Storm Water Compliance Inspection Form

Permit Tracking #: NMR1002FV, NMR1002GI

Owner: Presbyterian Healthcare Services

**EROSION
& SEDIMENT
CONTROL PLAN**

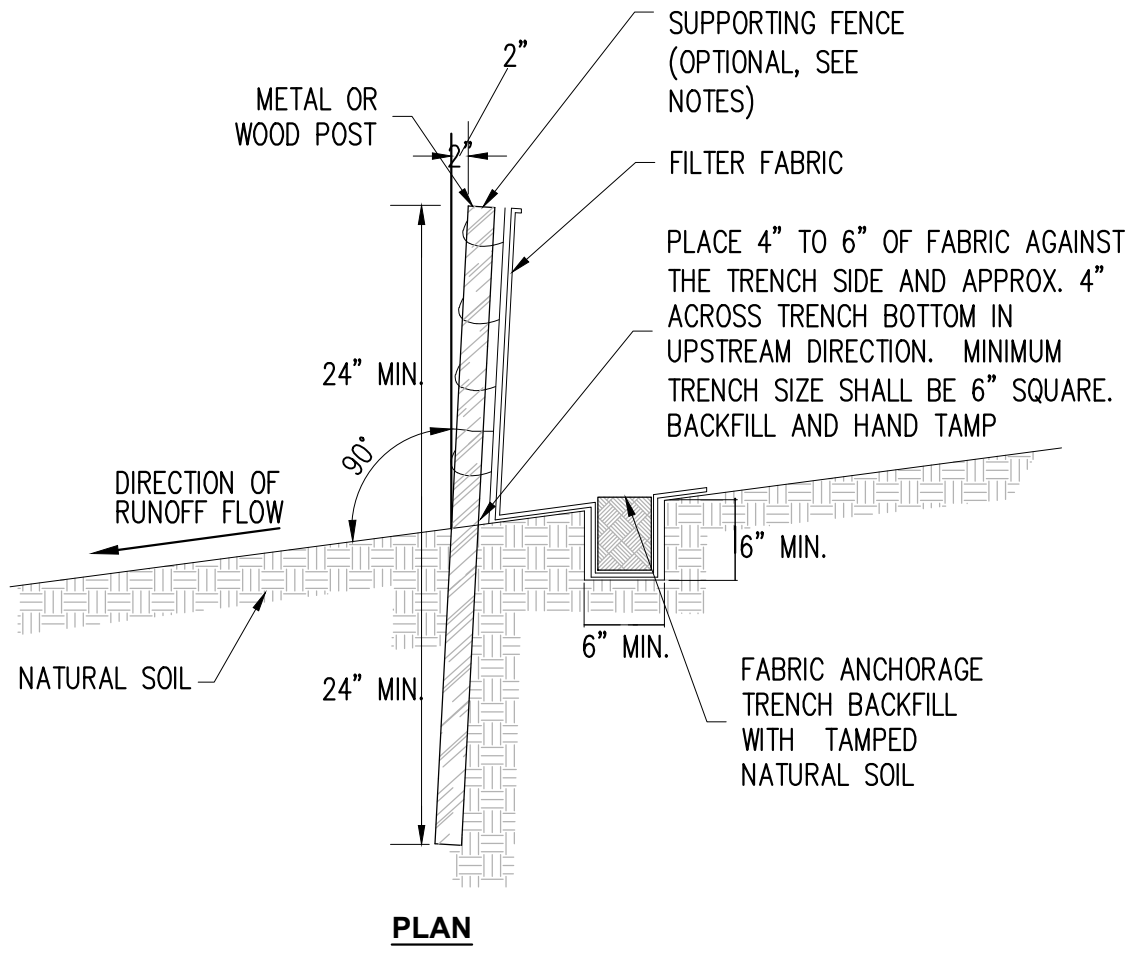
Waste Management	<input checked="" type="checkbox"/>	<input type="checkbox"/>	<input type="checkbox"/>	
Vehicle Tracking Control	<input type="checkbox"/>	<input checked="" type="checkbox"/>	<input type="checkbox"/>	Need to install VTC on both entrances on the west Monitor trackout sweep as necessary Sweeper on site
Material Storage	<input checked="" type="checkbox"/>	<input type="checkbox"/>	<input type="checkbox"/>	
Dust Control	<input checked="" type="checkbox"/>	<input type="checkbox"/>	<input type="checkbox"/>	
Street Sweeping	<input type="checkbox"/>	<input checked="" type="checkbox"/>	<input type="checkbox"/>	
Construction Washouts i.e. Concrete, Paint, Stucco Etc.	<input checked="" type="checkbox"/>	<input type="checkbox"/>	<input type="checkbox"/>	
Discharge Points	<input checked="" type="checkbox"/>	<input type="checkbox"/>	<input type="checkbox"/>	
Sanitary Stations	<input checked="" type="checkbox"/>	<input type="checkbox"/>	<input type="checkbox"/>

Location	Action Type	Action Required	Date Noted	Date Completed	Initials
Inlet Protection - Silver and Oak	Corrective Action	Repair or Replace Filter sock around inlets	07-22-2020		
North west entrance	Maintenance	Need to sweep street	05-08-2020		
VTC	Maintenance	VTC needs to be installed on the north west entrance	06-12-2020		
VTC - Silver and Oak	Corrective Action	Need to install VTC/Rock pad at access points	07-22-2020		
Sweep Street - Frontage rd	Corrective Action	Sweep street for heavy trackout. Sweeping was on going while on site.	07-24-2020
